25 May 2022

TfNSW Reference: SYD21/00188/04

Department's Reference: SSD-14378717

**RESPONSE TO SUBMISSIONS FOR TELOPEA CONCEPT PLAN & STAGE 1A
RESIDENTIAL, RETAIL, CHILD CARE & AGED CARE - ADDERTON ROAD, TELOPEA**

STATUS:
ISSUE FOR DA APPROVAL
NOT FOR CONSTRUCTION
THIS DRAWING MUST NOT BE USED FOR CONSTRUCTION UNLESS SIGNED AS PART OF AN APPROVED CONSTRUCTION CERTIFICATE.

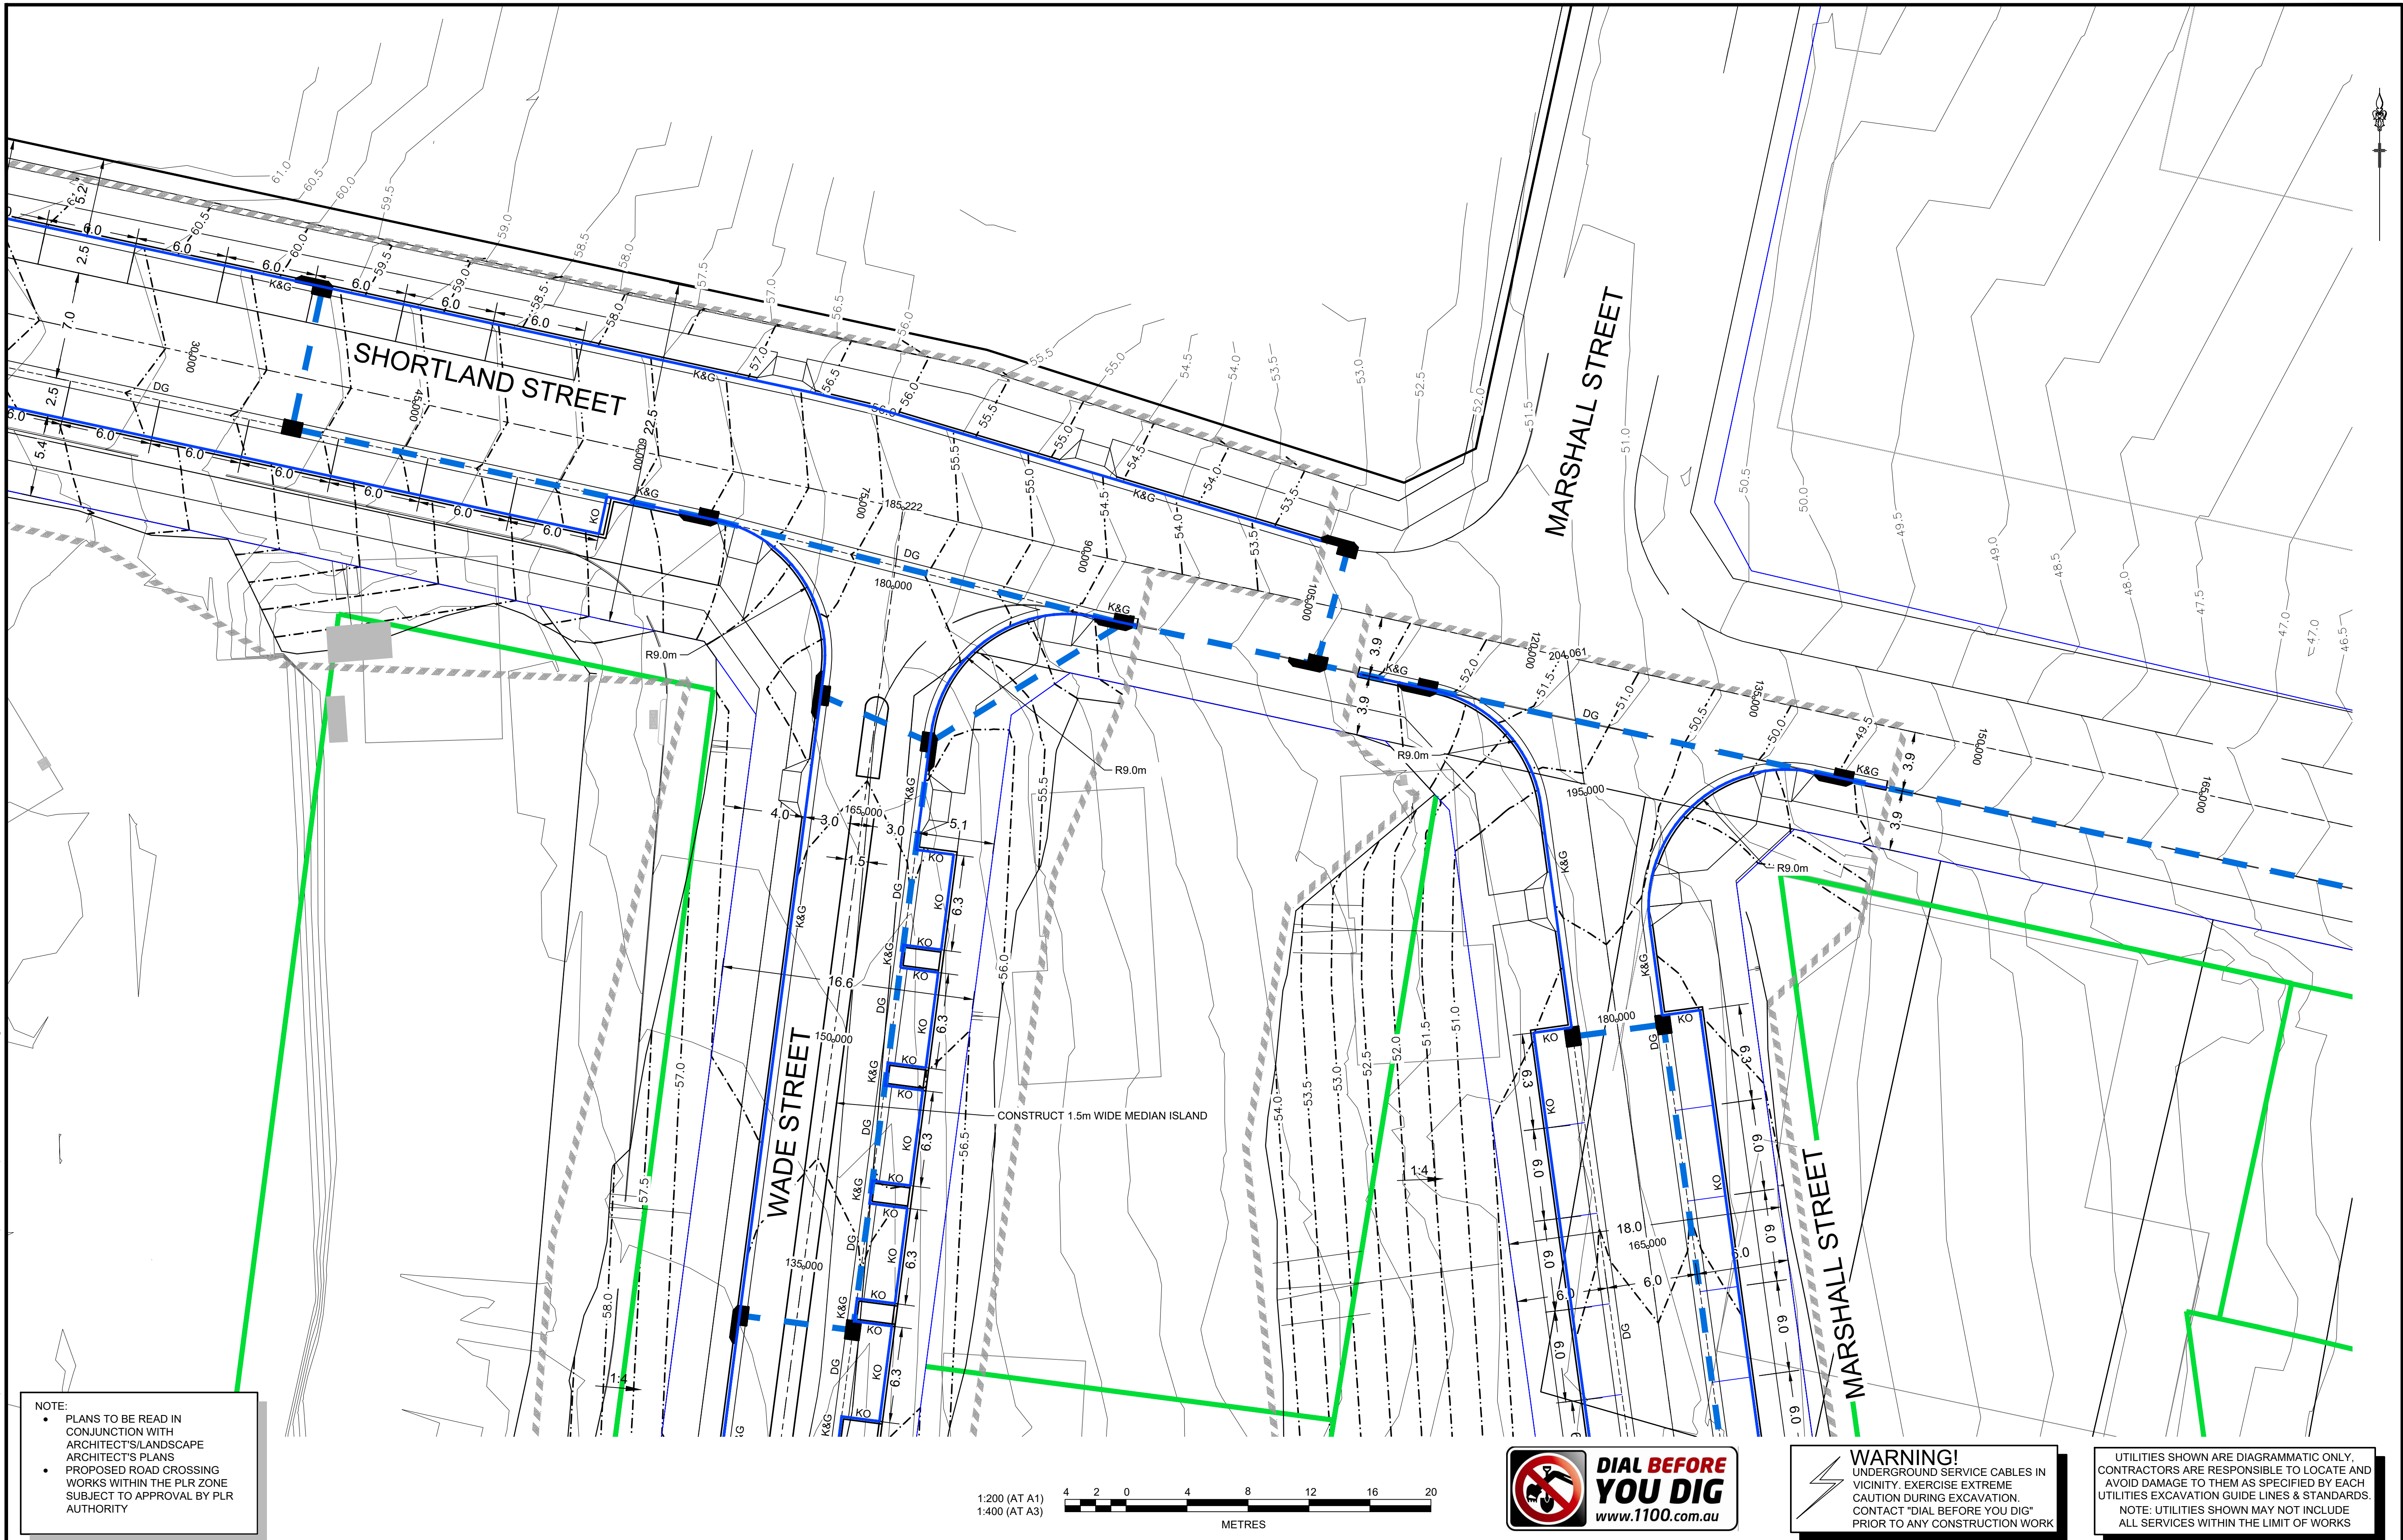
2. Comment 5 in the previous TfNSW for SSD-14378717 dated 20 December 2021 has not been adequately addressed. Relocation of the proposed TCS on Adderton Road/New Link Road is be reflected in resubmitted civil design plans and amended SIDRA modelling.
3. The TfNSW concerns regarding the proximity of the proposed intersection to the mid-block signals near Roberts Street is still a concern and has not been addressed.
4. New Link Road is proposed to be a single lane on approach. There are conflicting

pedestrian crossings and required pedestrian protection time will result in no traffic coming out of the side street (Sturt Street). TfNSW requests two lanes on this approach.

7. There is a proposed 3% crossfall gradient on both sides of the New Link Road verge that is not aligned to the light rail alignment (2.5% crossfall gradient to the south). Amended civil plans should be submitted showing the grade pavement at crossing is flush with the light rail.

11. The footpath and pedestrian crossing are not aligned to the location of the Overhead Wire pole JC5+236 which is a potential *Disability Discrimination Act 1992 (DDA)* compliance issue. The footpath and pedestrian crossing should be amended in resubmitted civil plans.

15. The stop line on the intersection layouts for Adderton Road/New Link Road should be located as close to the intersection as possible to minimise inter-green time and improve sight distances.
